From: DFW R4Cplanning <R4Cplanning@dfw.wa.gov>
Sent: Tuesday, August 1, 2023 9:45 AM
To: Chris Holland
Cc: Lakey, Kirk A (DFW)
Subject: [External!]RE: Dell's Nursery Rezone - Notice of SEPA (PA22041)

Thank you for the opportunity to comment on this project (PA22041). Our comments are mostly for clarity:

Project Name: Dell's Nursery Rezone

Description: Site Plan Approval and Concurrent Rezone from Medium Density, Single-family (R-4.5) to General Commercial (GC) in order to construct two single story office/warehouse buildings totaling approximately 30,600 SF.

Sheet L-3

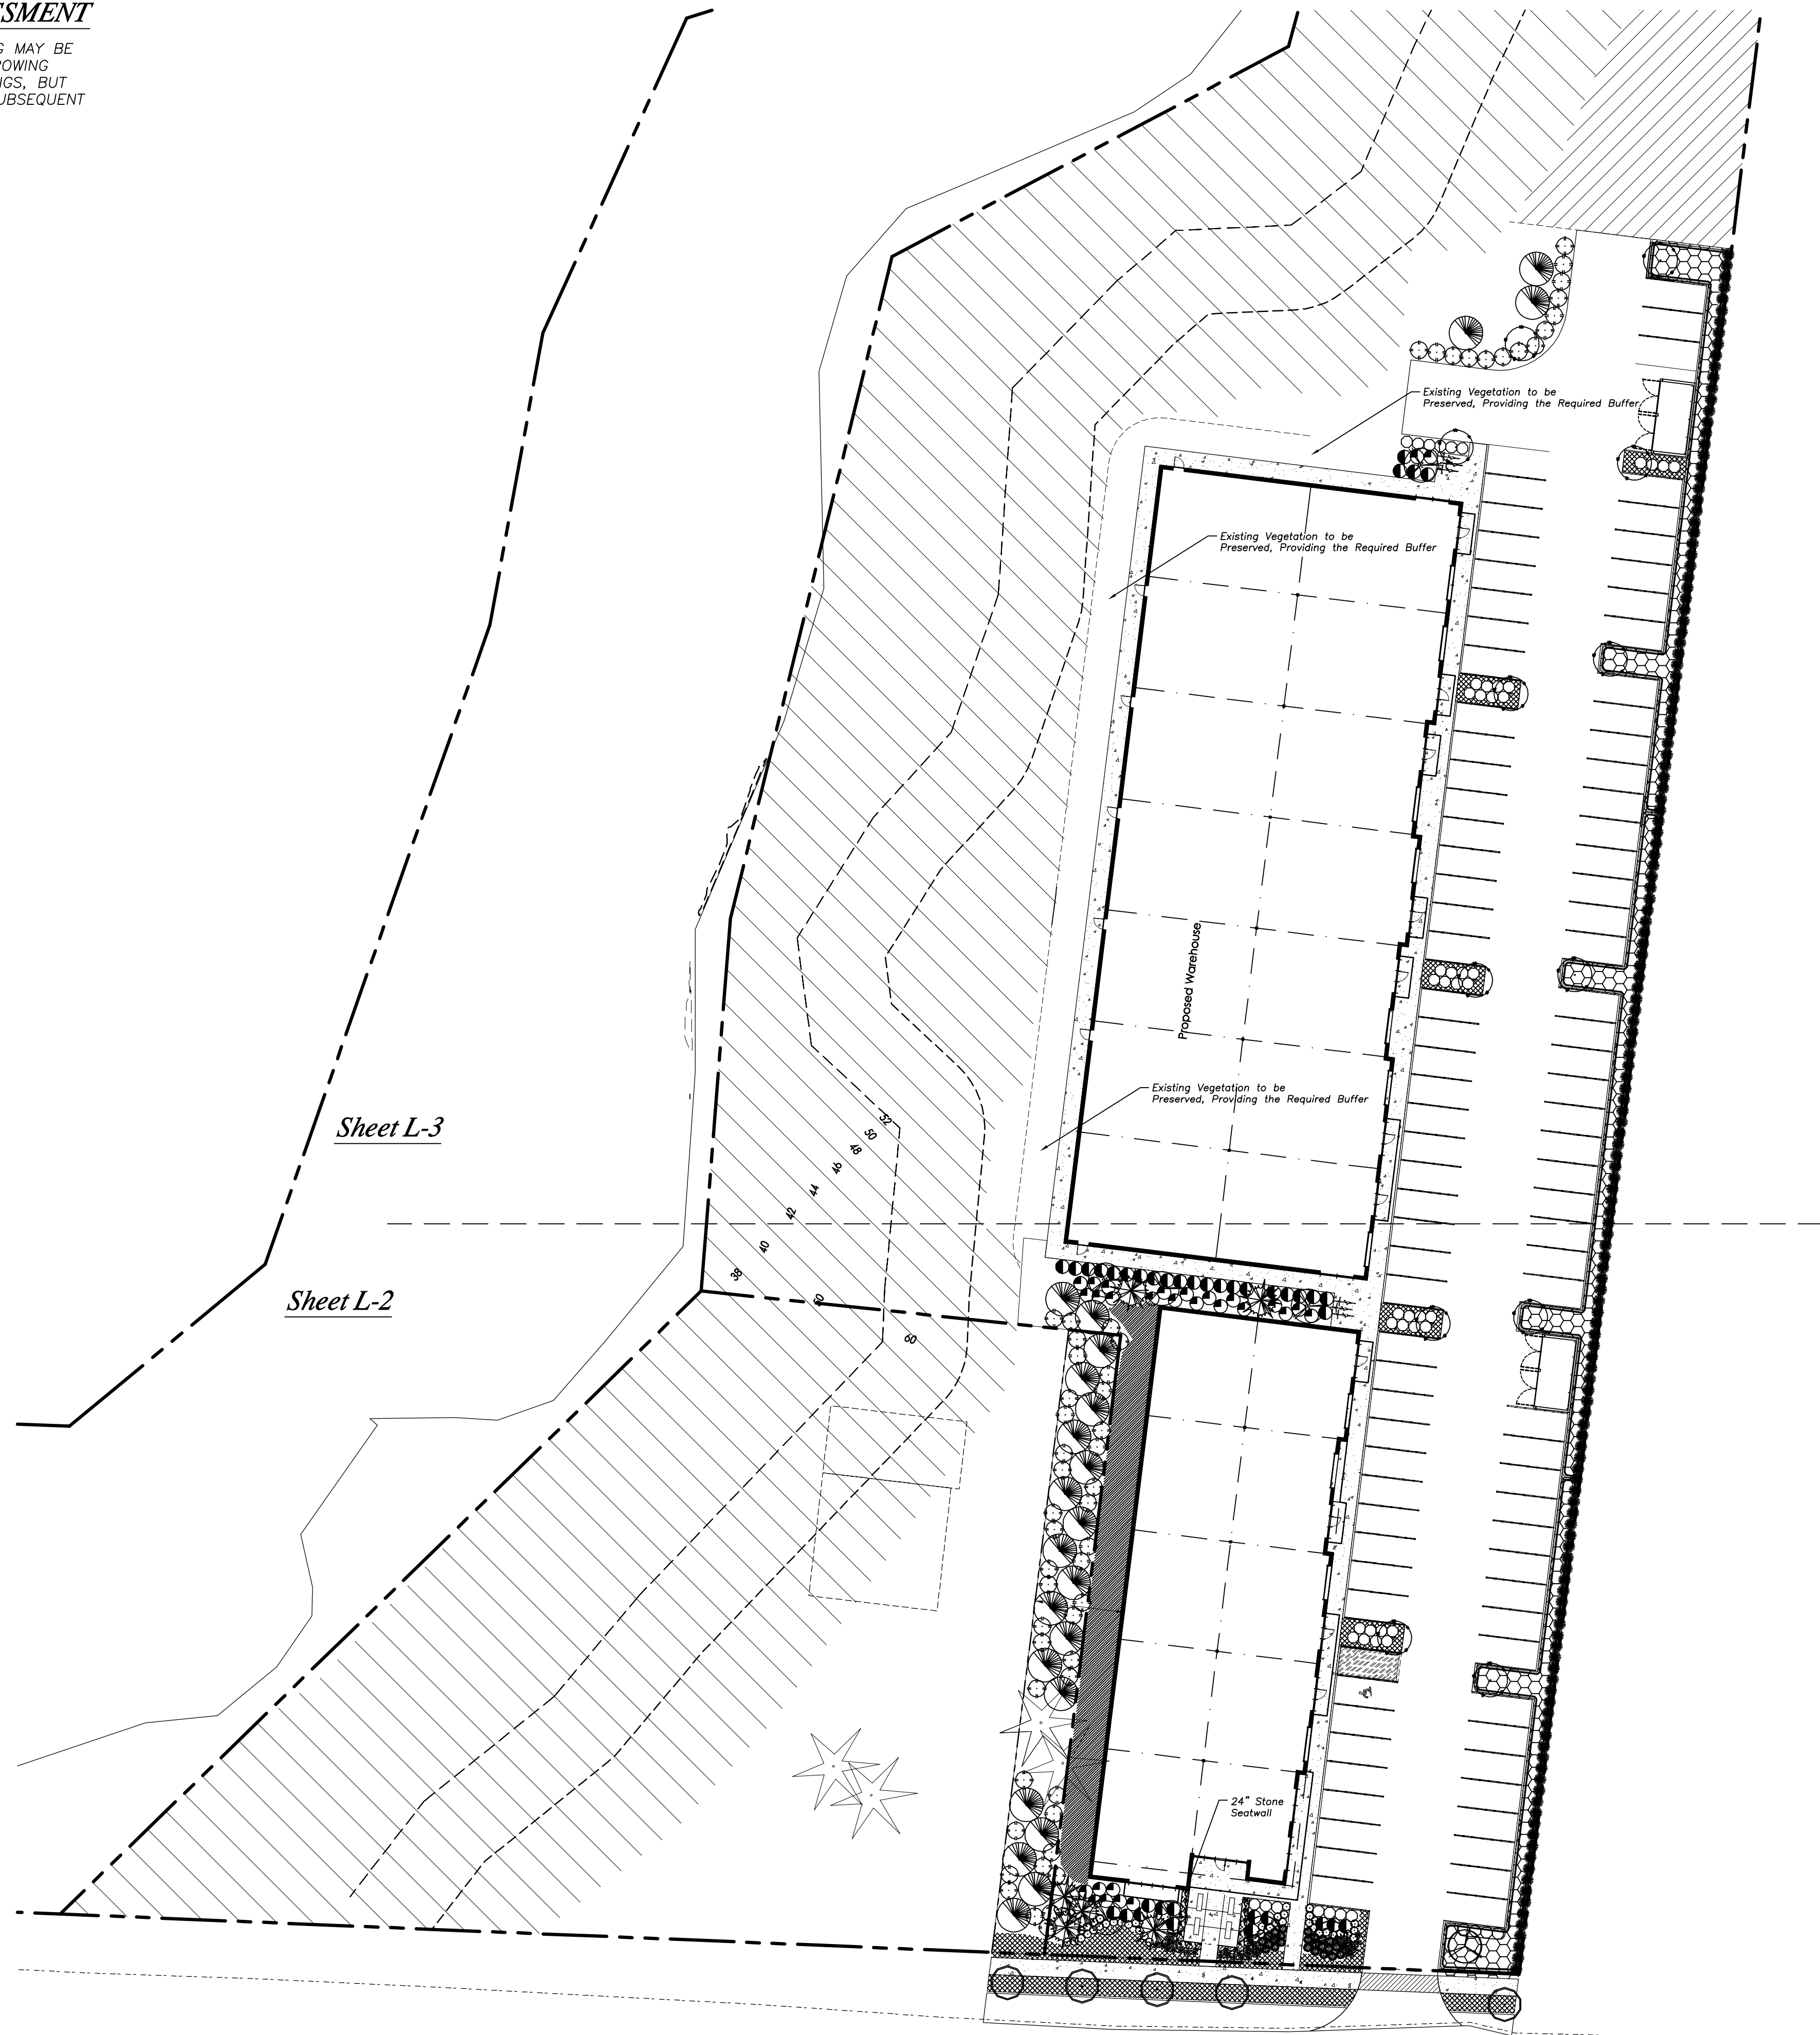
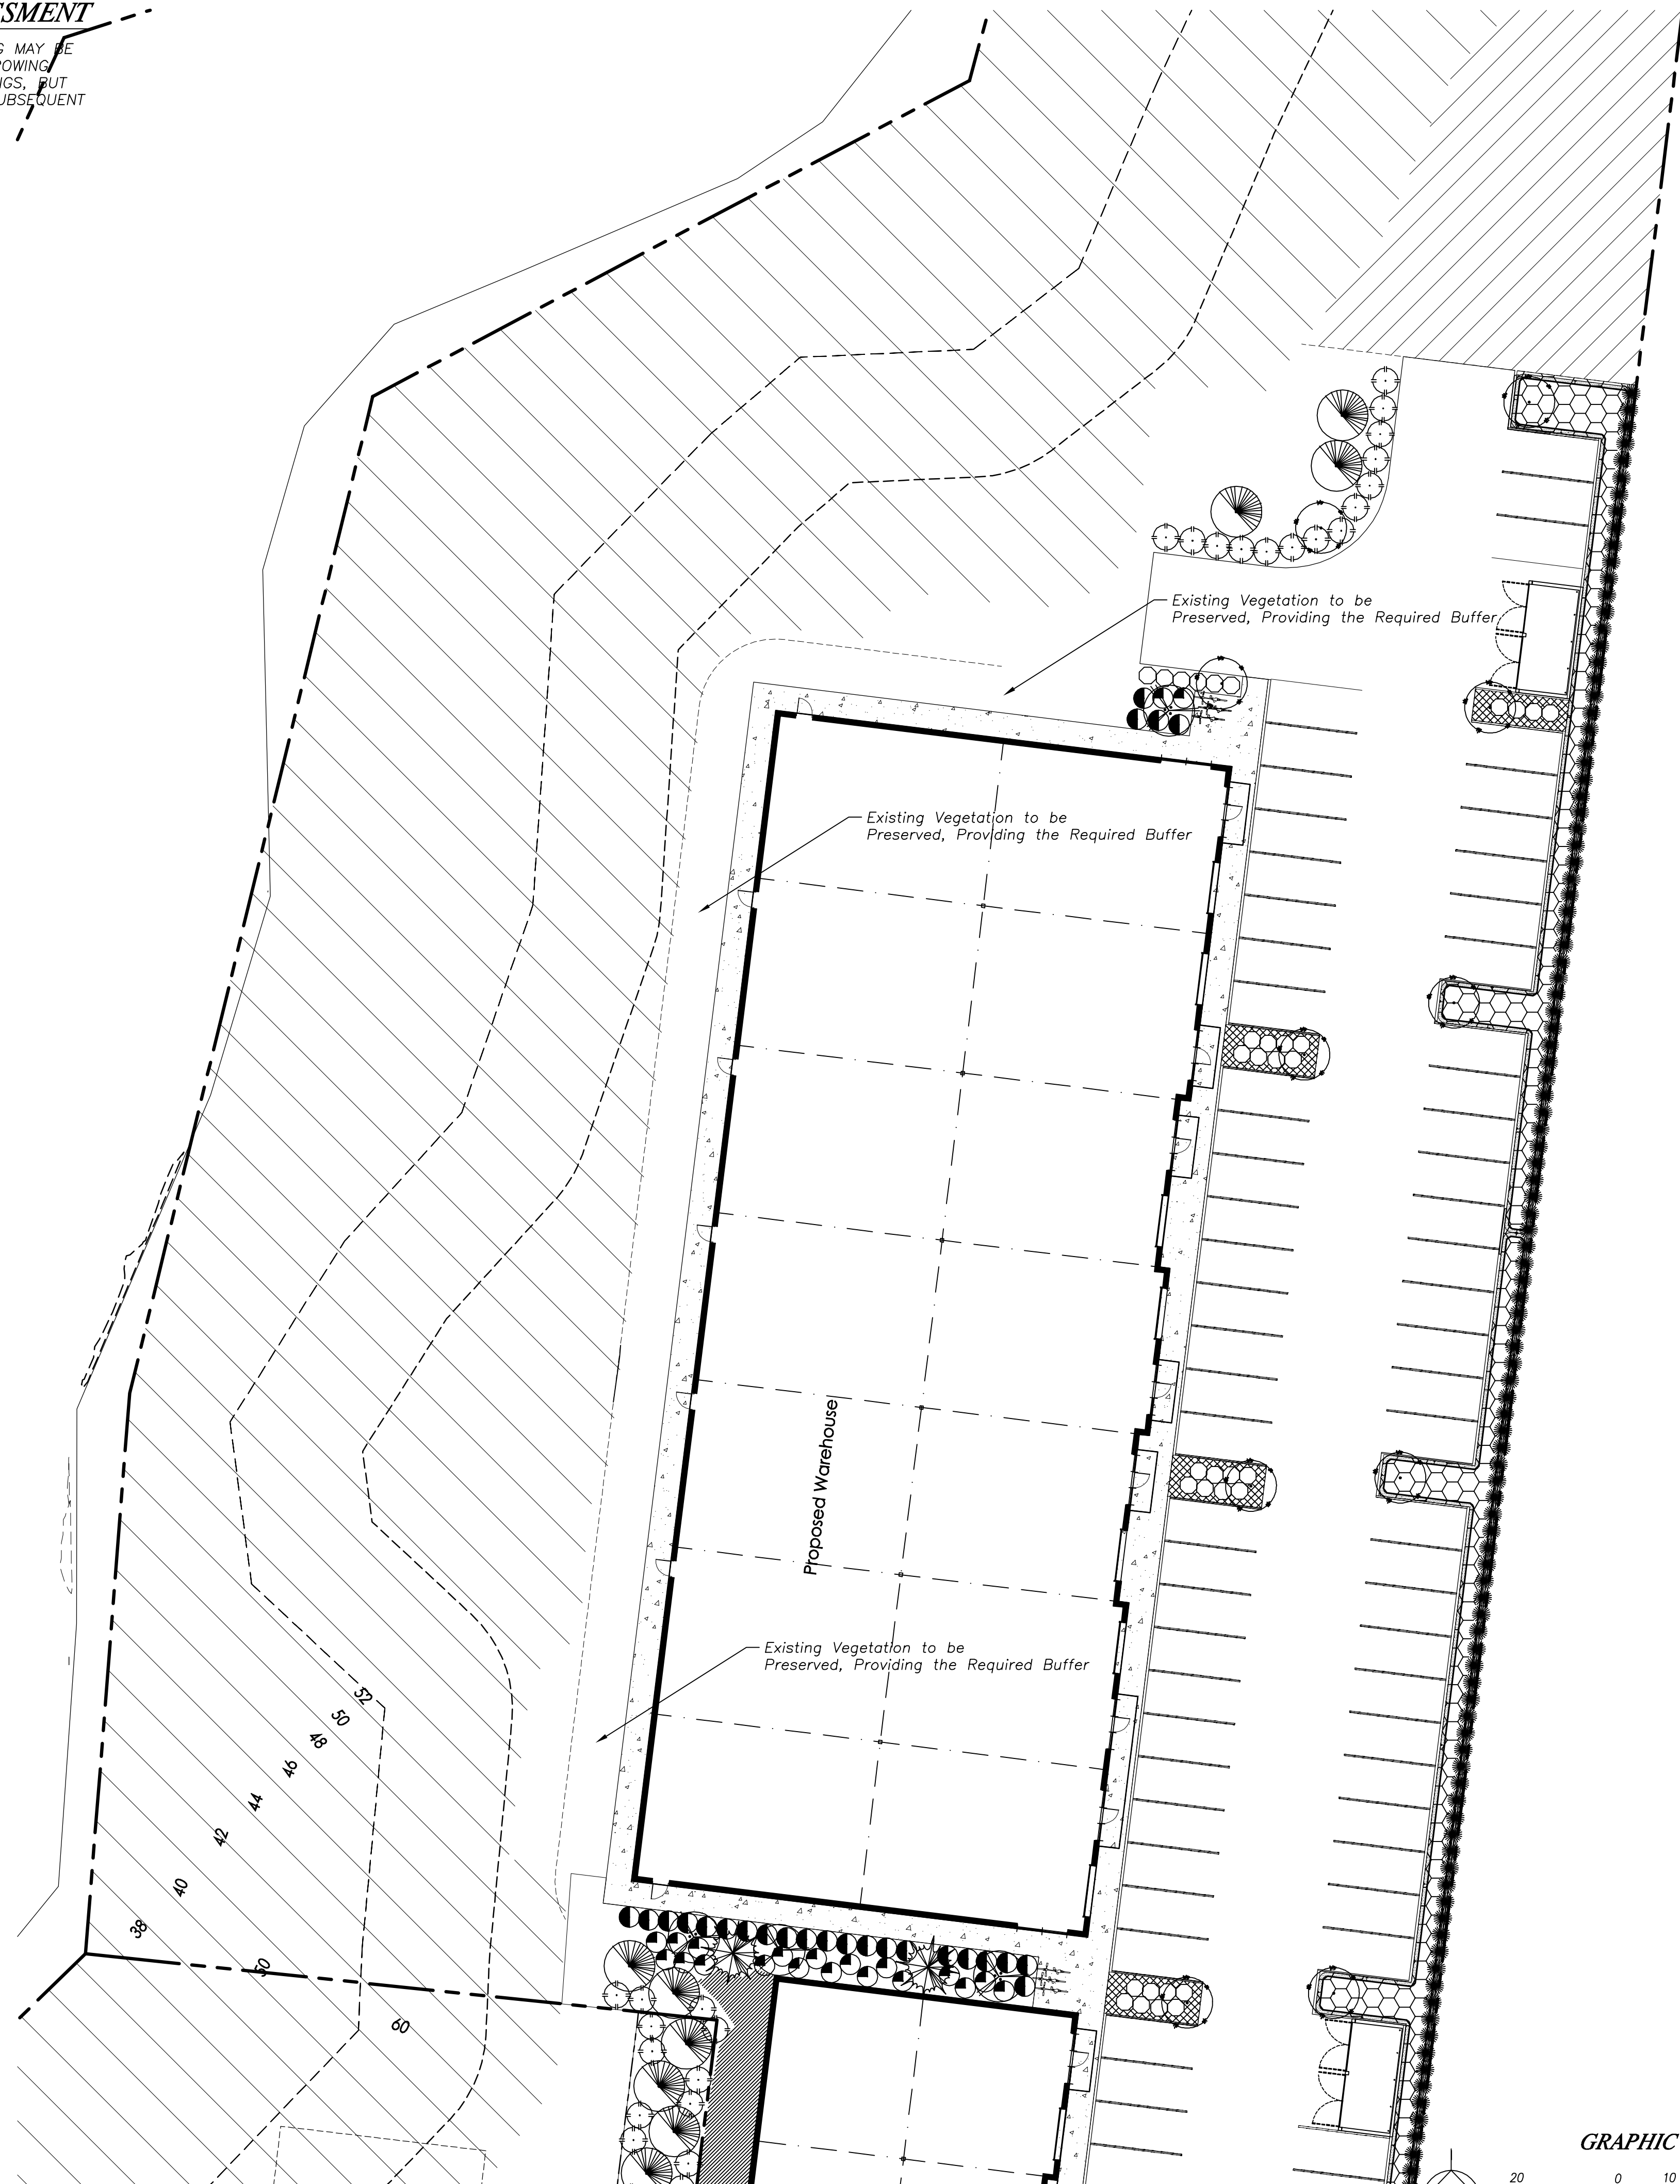
- On the landscape plan, the applicant does not seem to include their plans for the 'wetland buffer addition'. A clear plan outlining how this area will be restored and monitored is needed.
